RE: **Abrazo Homes**
Lot 4 Block 10 Unit 22 Volcano Cliffs SAD 228
6420 Petirrojo NW
Grading and Drainage Plan
Engineers Stamp Date 11/3/16 (D10D003F4)
Pad Certification Dated 1/10/16

RE: Abrazo Homes
Lot 4 Block 10 Unit 22 Volcano Cliffs SAD 228
6420 Petrojo NW
Grading and Drainage Plan
Engineers Stamp Date 11/3/16 (D10D003F4)

From: Rael, Rudy E.
Sent: Tuesday, November 01, 2016 9:11 AM
To: 'David Soule (david@riograndeengineering.com)'
Cc: Carrillo, Abiel X.
Subject: 6420 Petirrojo NW

ENGINEER'S SEAL 10/26/16 DAVID SOULE P.E. #14522	LOT 4, BLOCK 10, UNIT 22 VOLCANO CLIFFS SUBDIVISION GRADING AND DRAINAGE PLAN Rio Grande Engineering 1606 CENTRAL AVENUE SE SUITE 201 ALBUQUERQUE, NM 87106 (505) 872-0999	DRAWN BY JDG
		DATE 10-26-2016 SHEET # 1 OF 1 JOB #

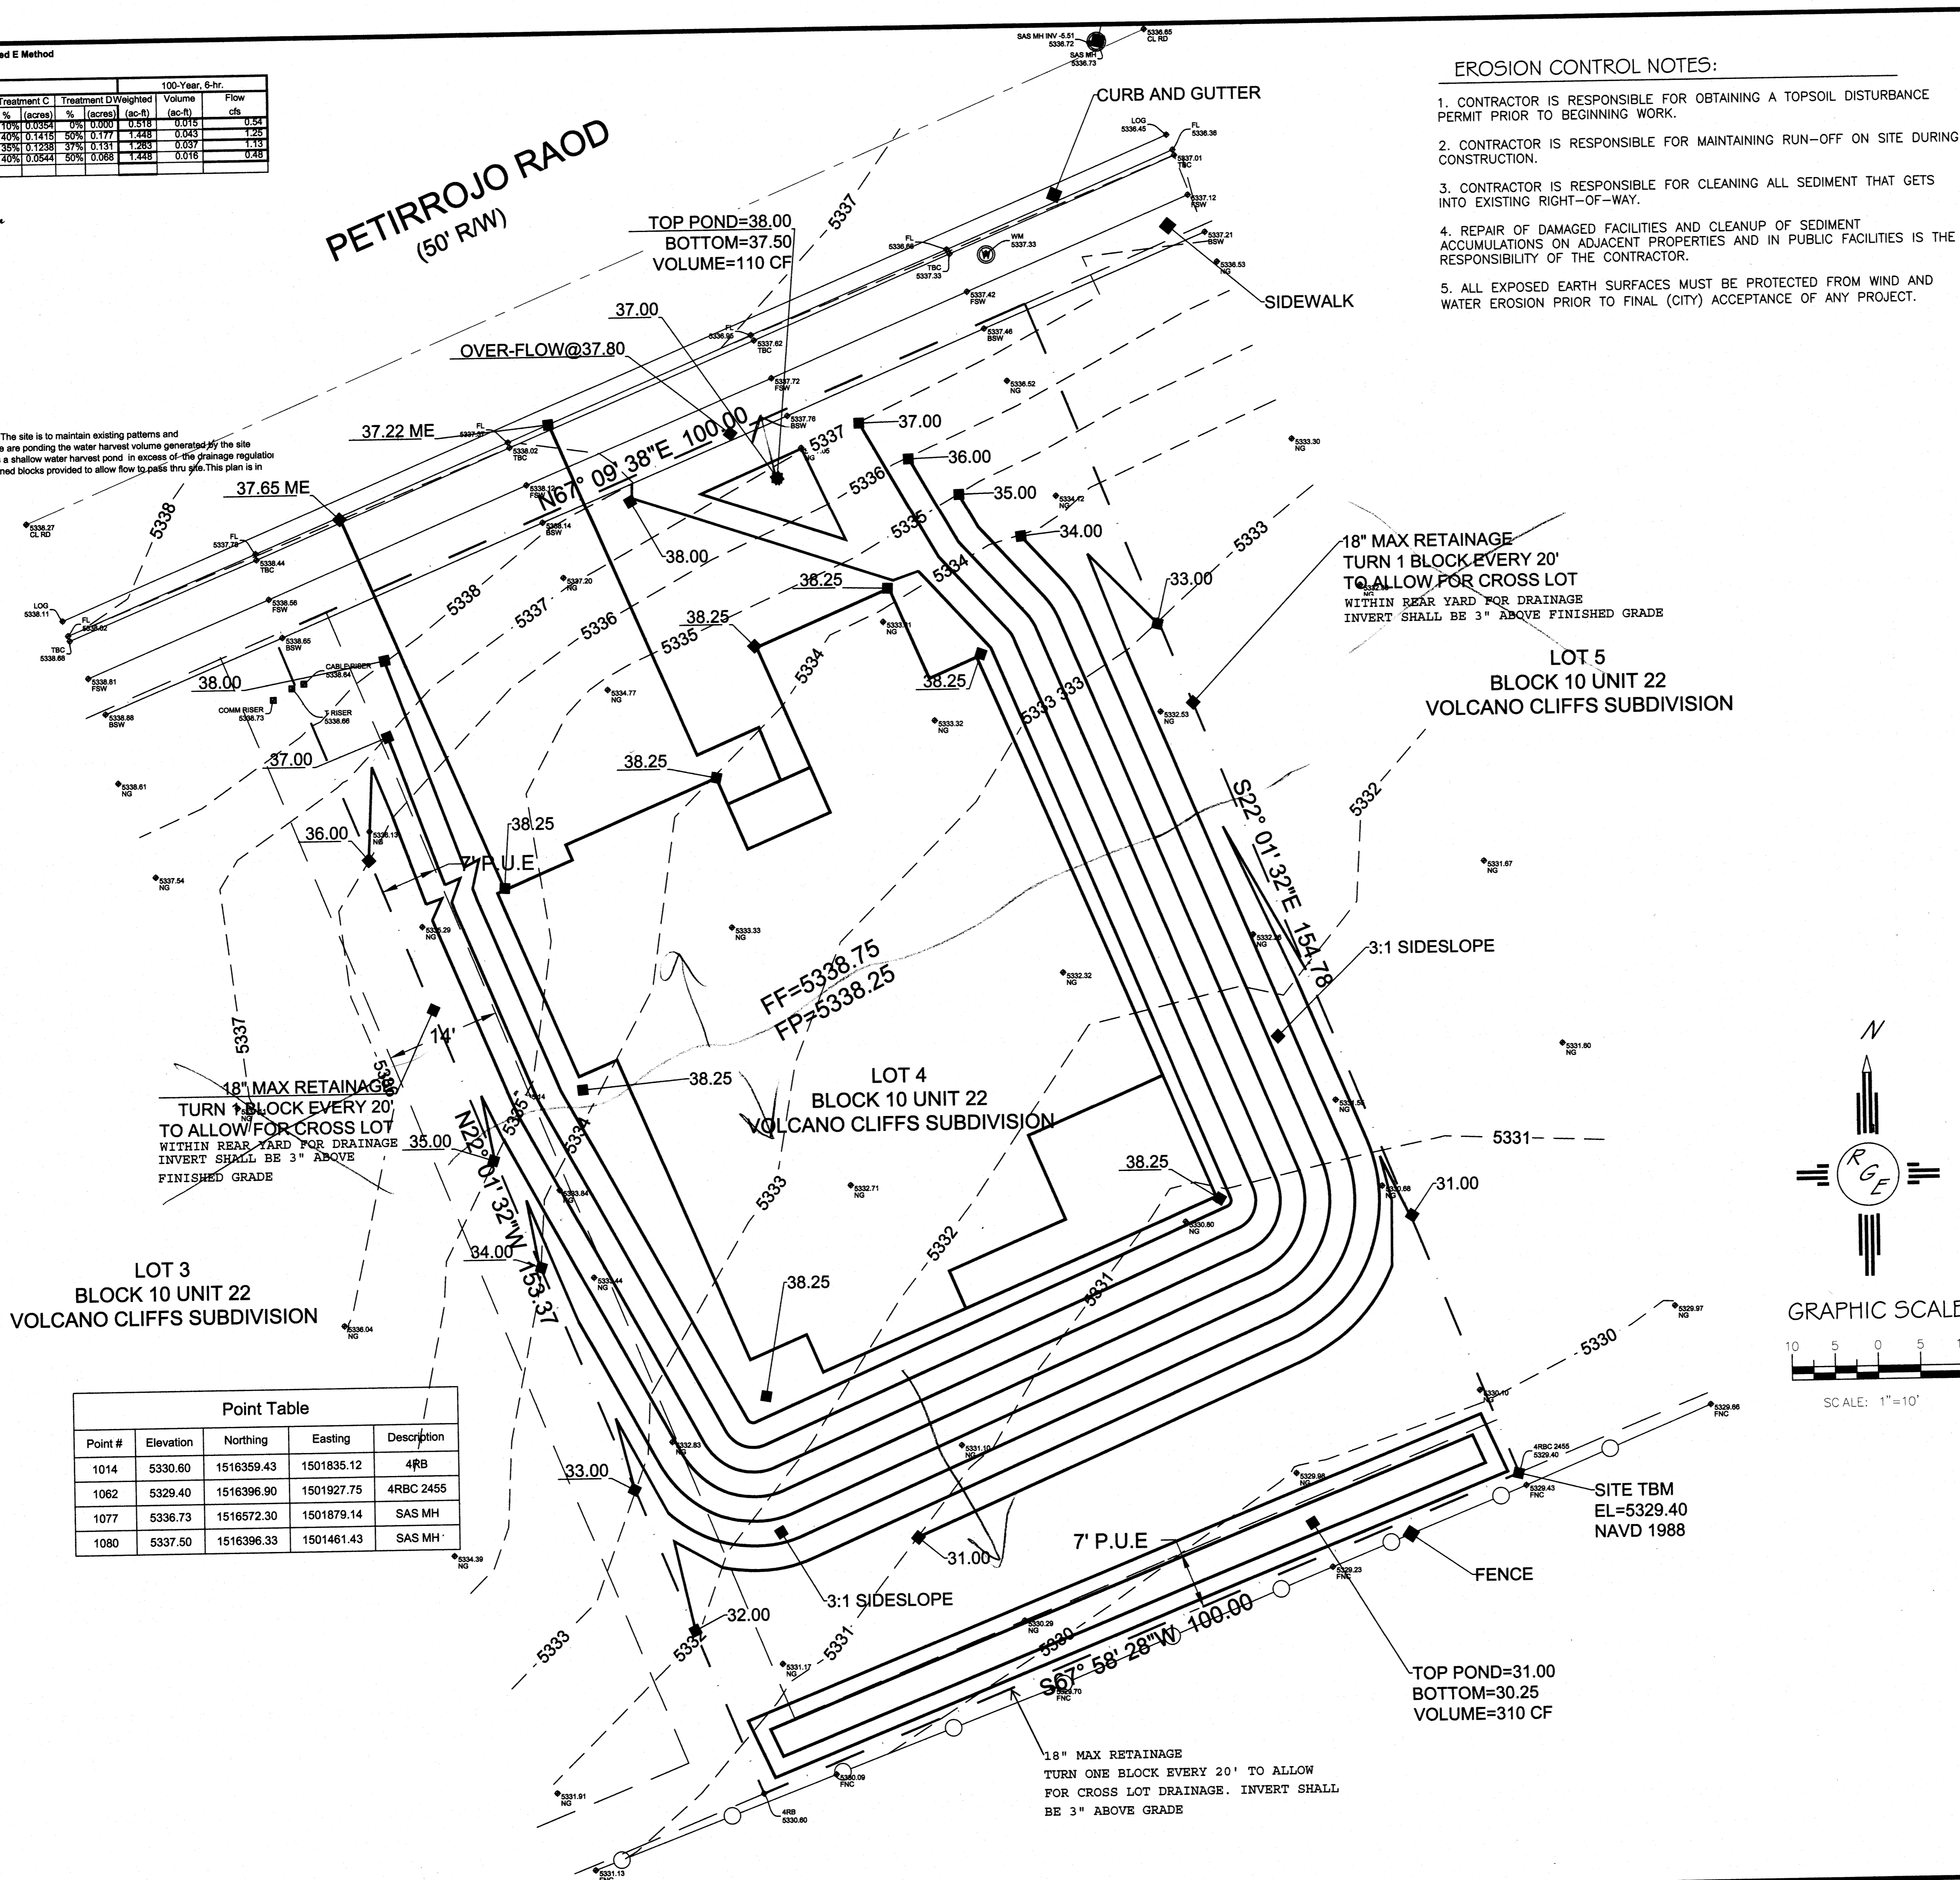
Based upon the information provided in your submittal received 10/26/16, the above referenced Grading and Drainage plan dated 10/26/16 cannot be approved for Grading Permit or Building Permit until the following comments are addressed:

- Enlarge the drainage calcs or provide on a separate sheet with the proper font size. Once submitted the calculations will be checked.
- Remove the statement, turn block every 20'.... This lot drains half toward the front and half toward the rear, going through a water Quality pond first.
- Provide a note stating the requirement that a separate wall permit must be provided when the fence is being built, at time of Building permit or later. This plan needs to accompany the wall permit set, otherwise will not be approved.
- Provide a statement for the requirement of a pad certification before the concrete slab is poured or before rough in occurs.
